**Consultation Response from KC,
 Highways Development Management**
2023/93333 Cambridge Hotel, 4, Clare Hill, Huddersfield, HD1 5BS
Erection of 18 room extension to hotel
Date Responded: 22/02/2024
Responding Officer: CNB
Responding Ref: K5-8SW/39

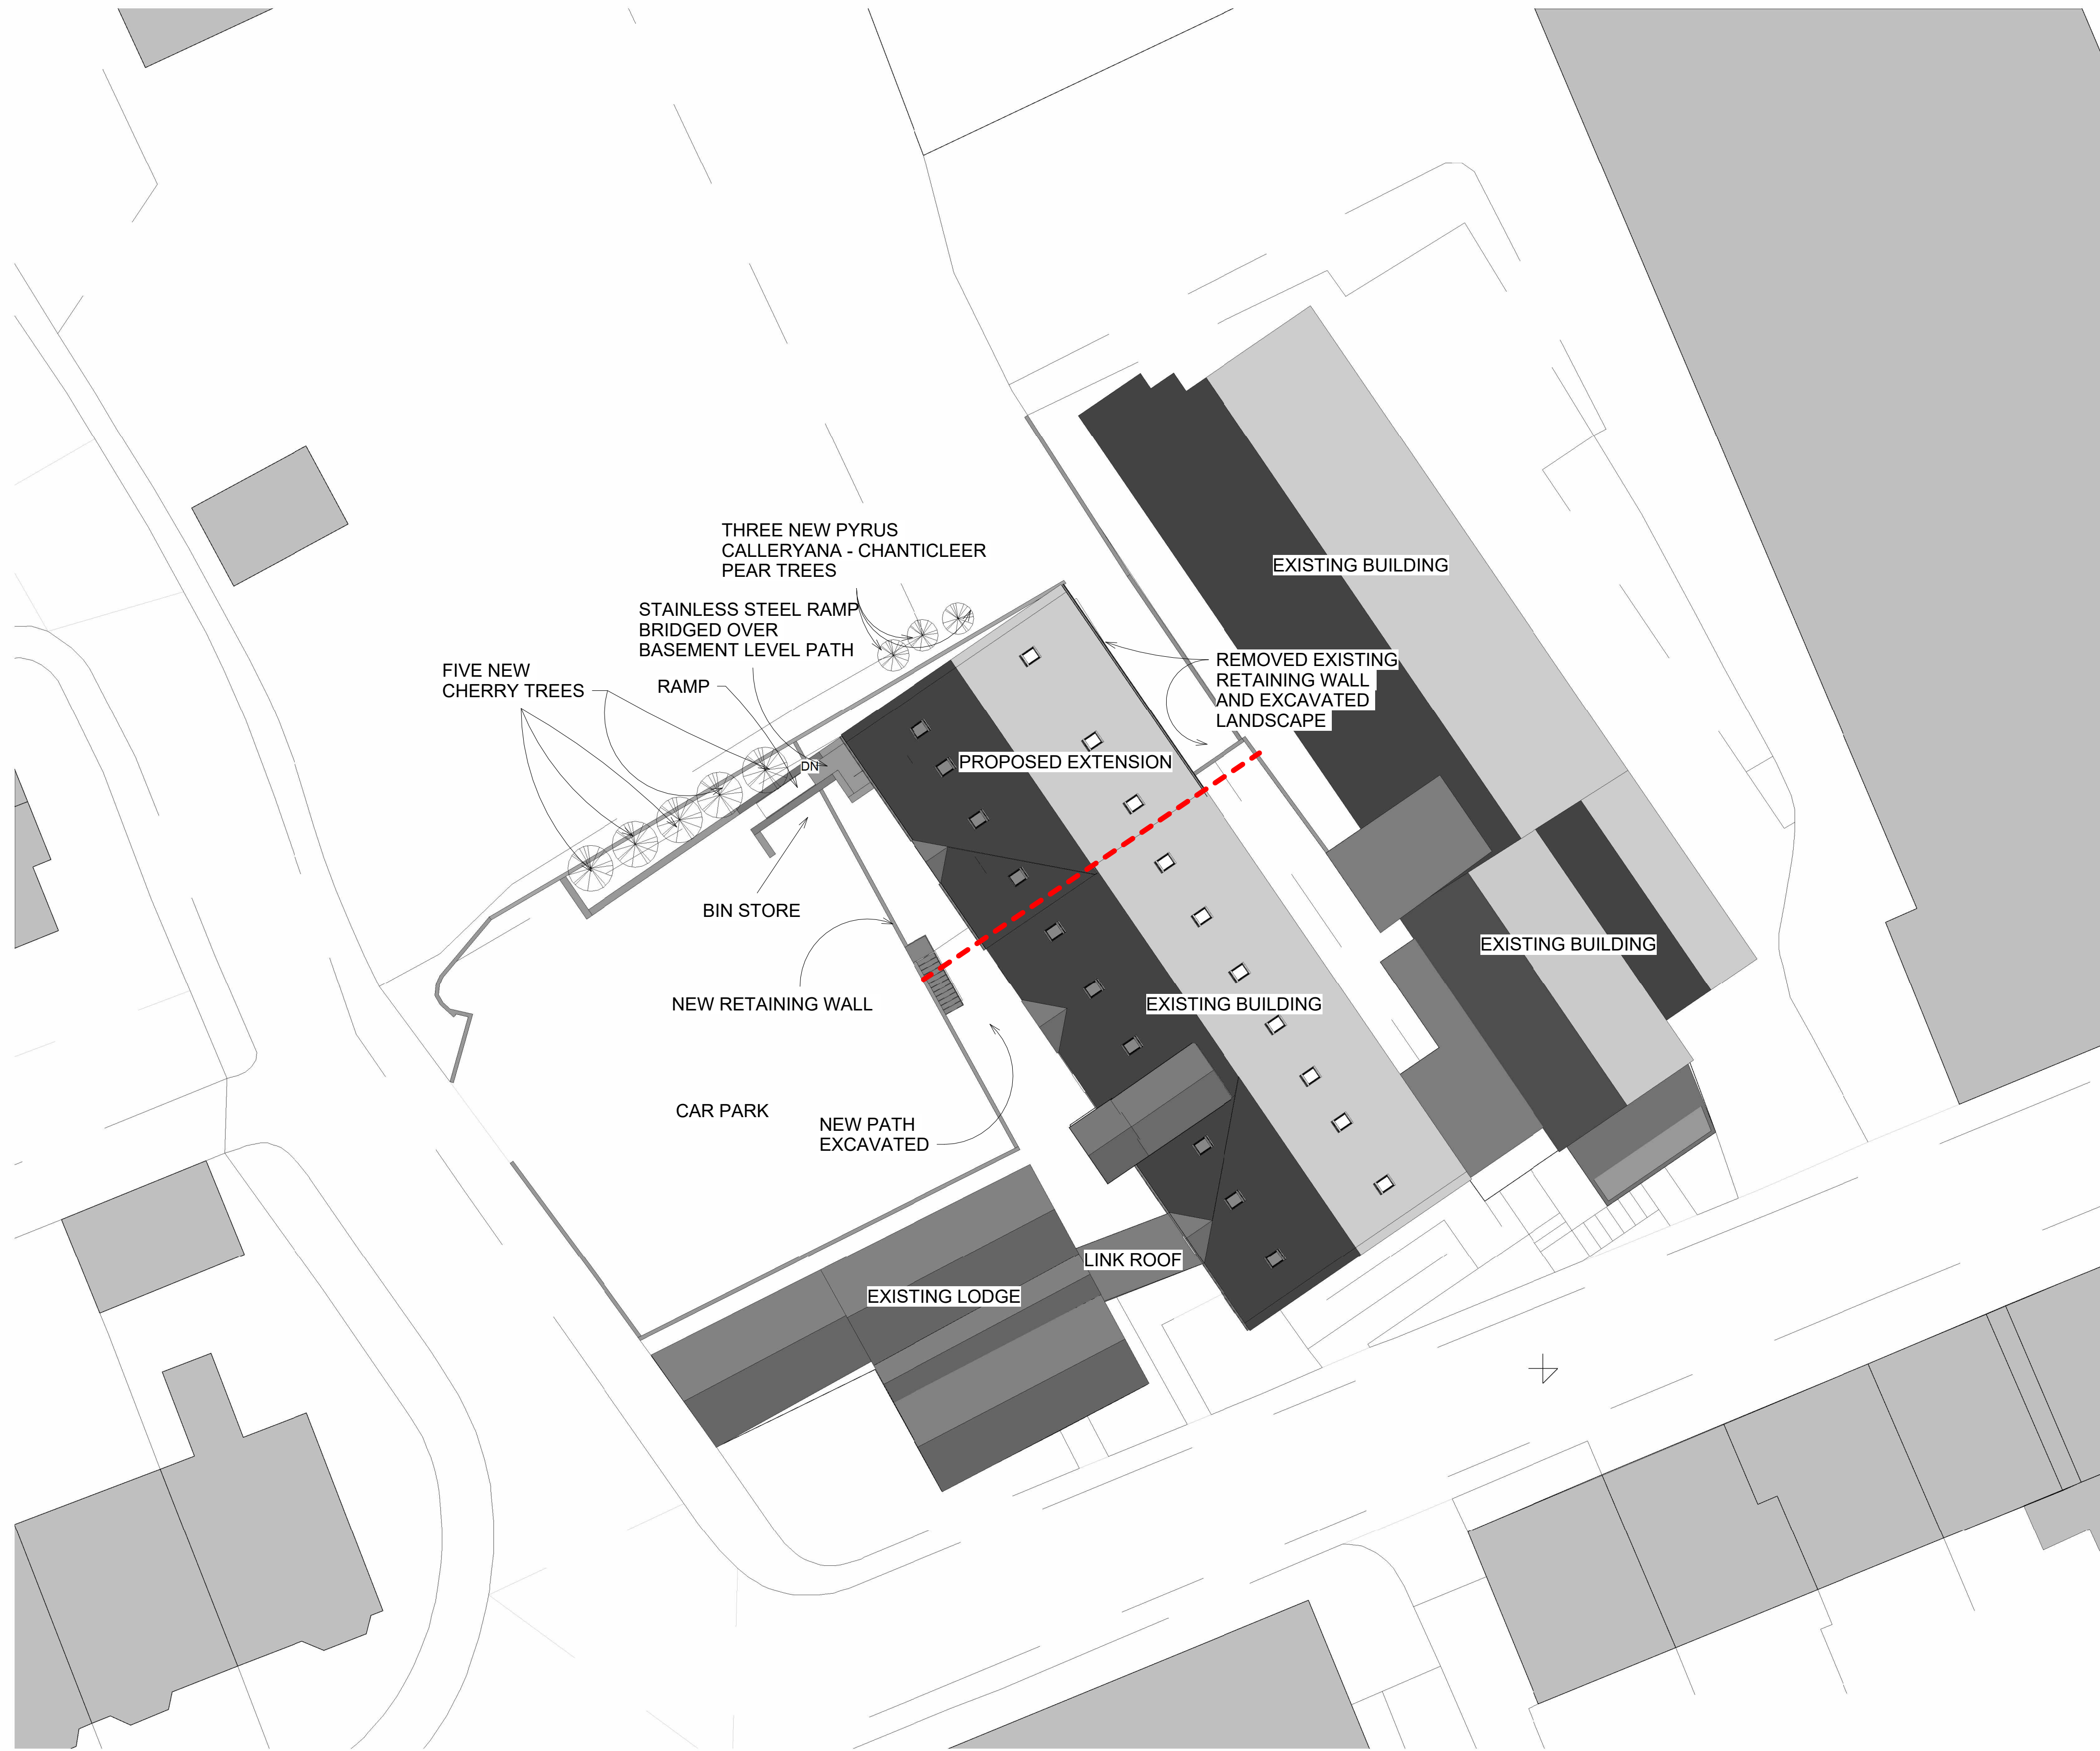
The site currently offers 77 car parking spaces, and no spaces will be removed due to the application proposals (information provided within the application form). This is incorrect as the site currently contains waste bin storage that is to be relocated and this would cause the loss of up to three car parking spaces. However given the remaining 74 car parking spaces, observed low use of the car park, existence of a large public car park and public transport links close by, and TRO parking restrictions in the surrounding streets, then this is not a concern.
